# Consultee Comments for Planning Application 23/00921/FUL

Application Number: 23/00921/FUL

Proposal: Linked extension to provide covered cycle and refuse storage areas and new Class E unit with disabled w.c.

Name: Mr Coast Protection & Land Drainage Officer

Drawing No. <b>D2110-PL300</b>	Rev. <b>-</b>
-----------------------------------	------------------

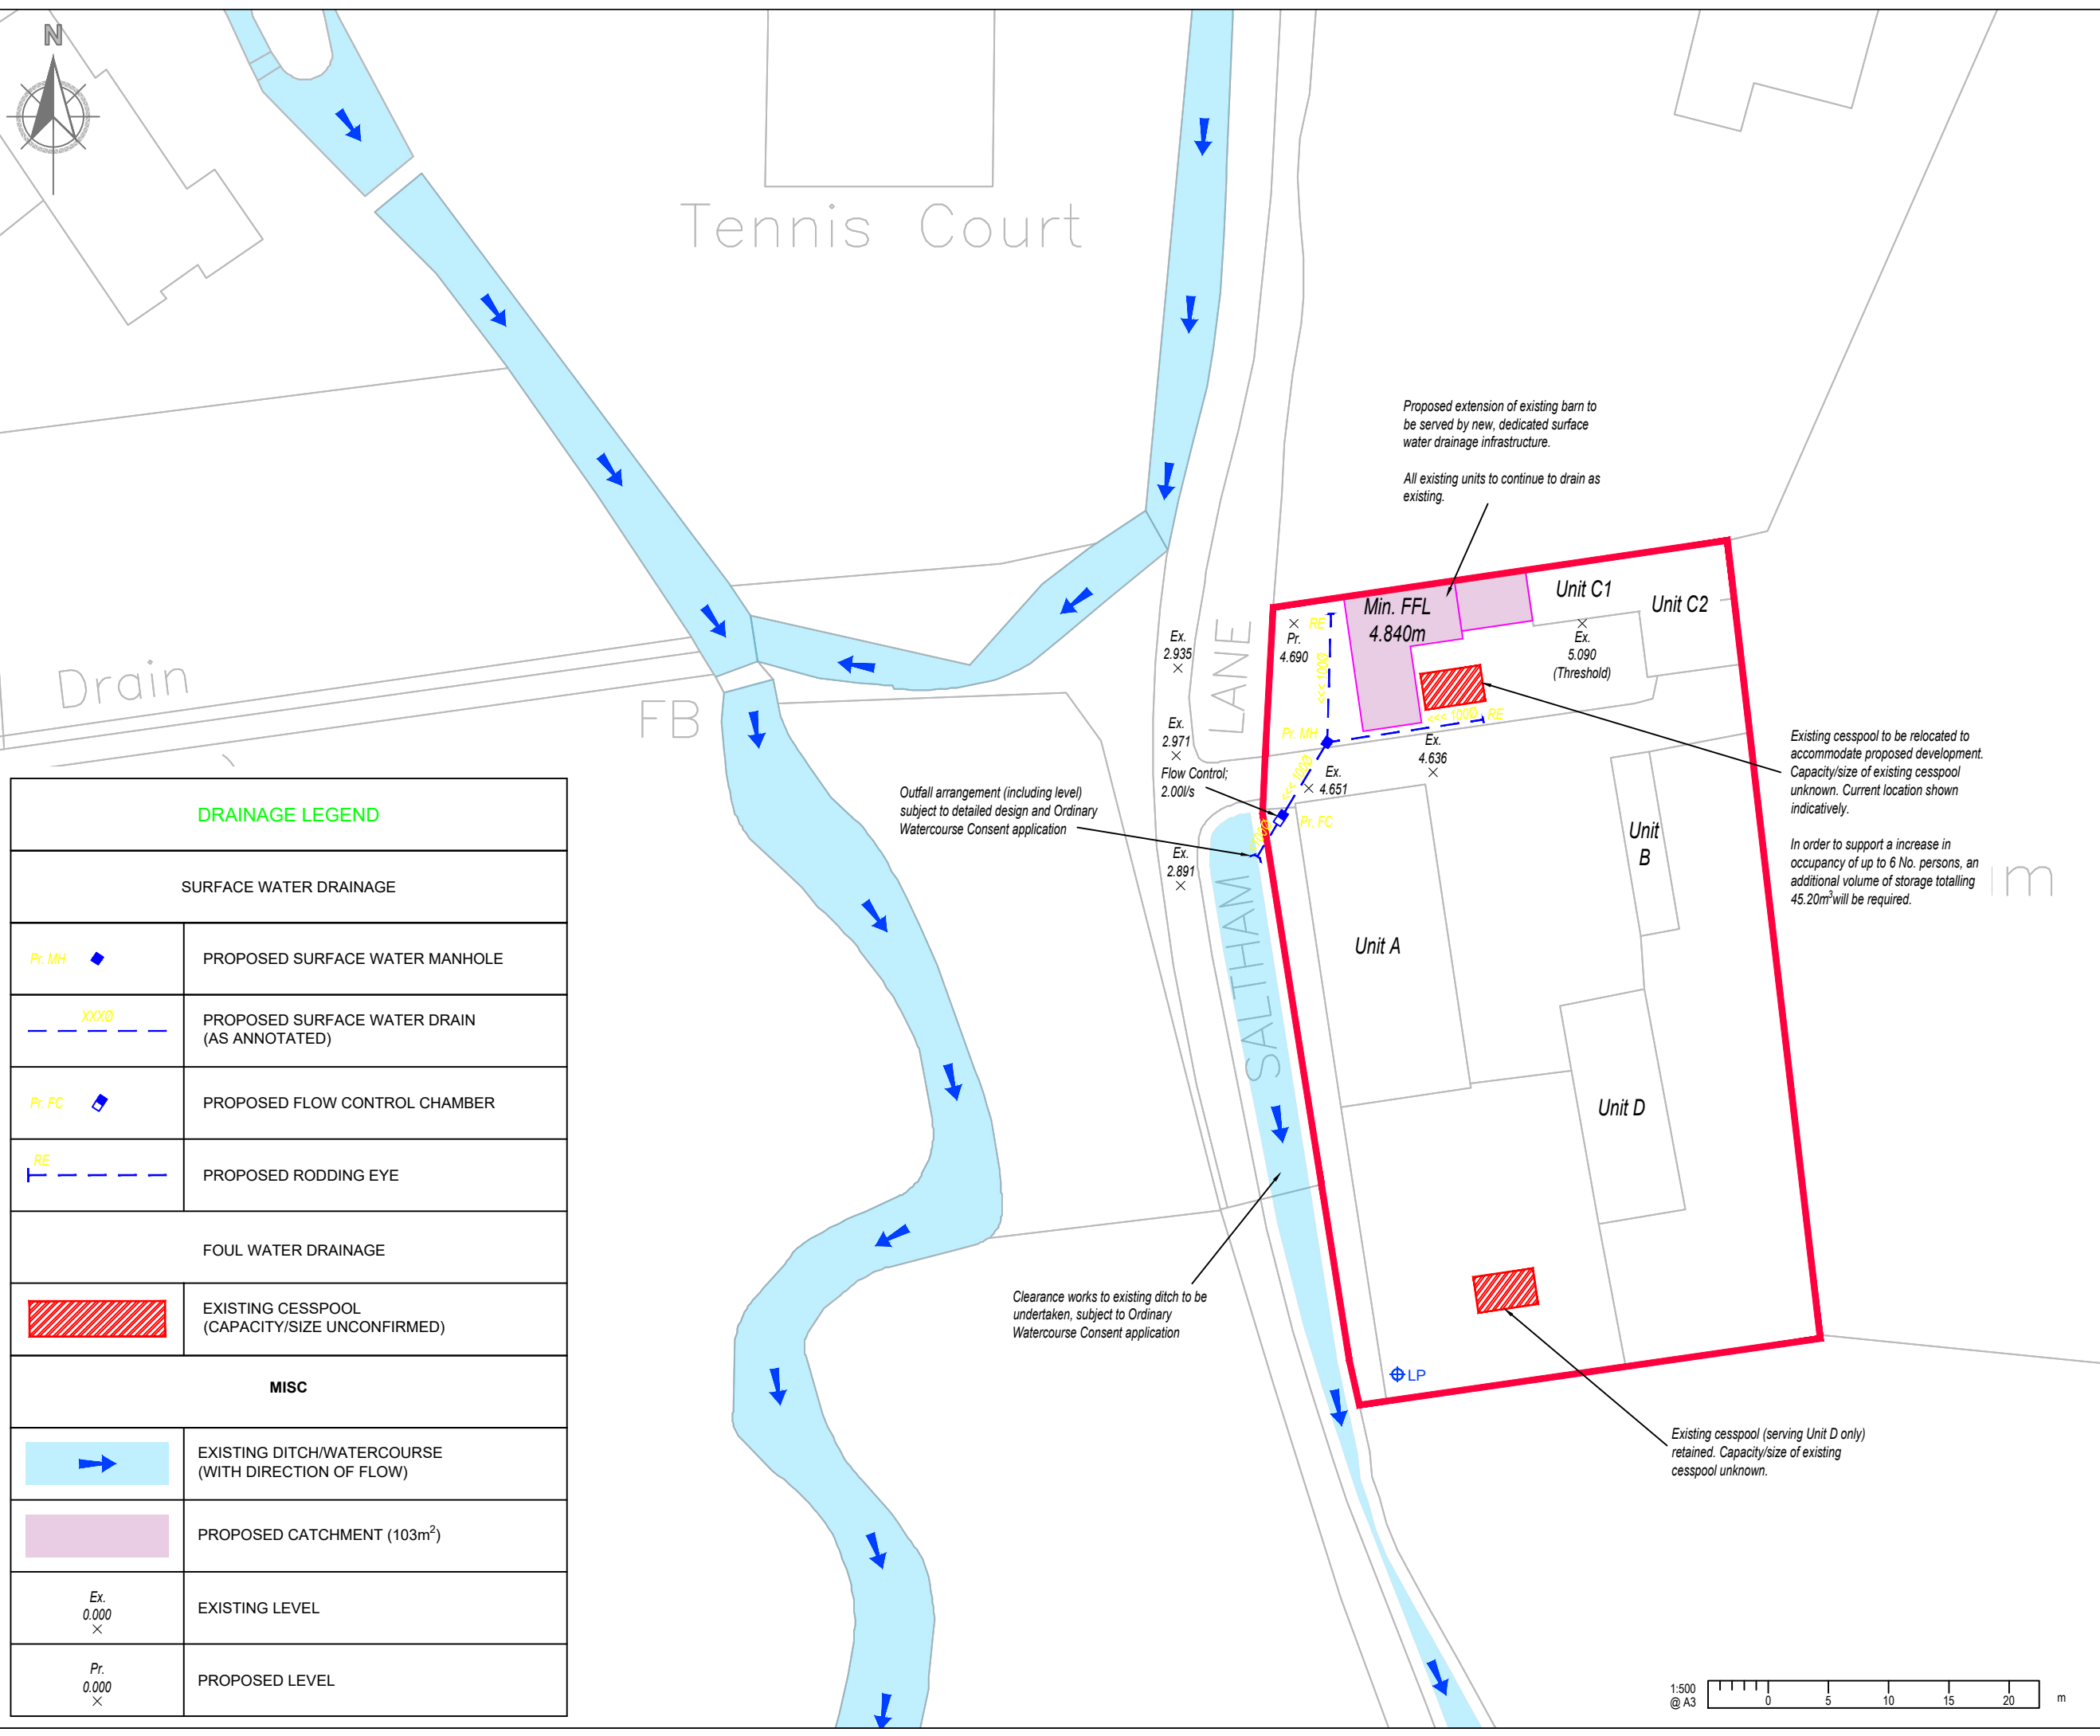
Surface Water Drainage: The proposal is a restricted (2l/s) discharge to an adjacent watercourse. This approach is acceptable in principle as infiltration is unlikely to be viable in this location. Wherever possible, driveways, parking spaces, paths and patios should be of permeable construction. Due to the scale of the proposed development we have no conditions to request. Surface water drainage should be designed and constructed to meet building regulations.
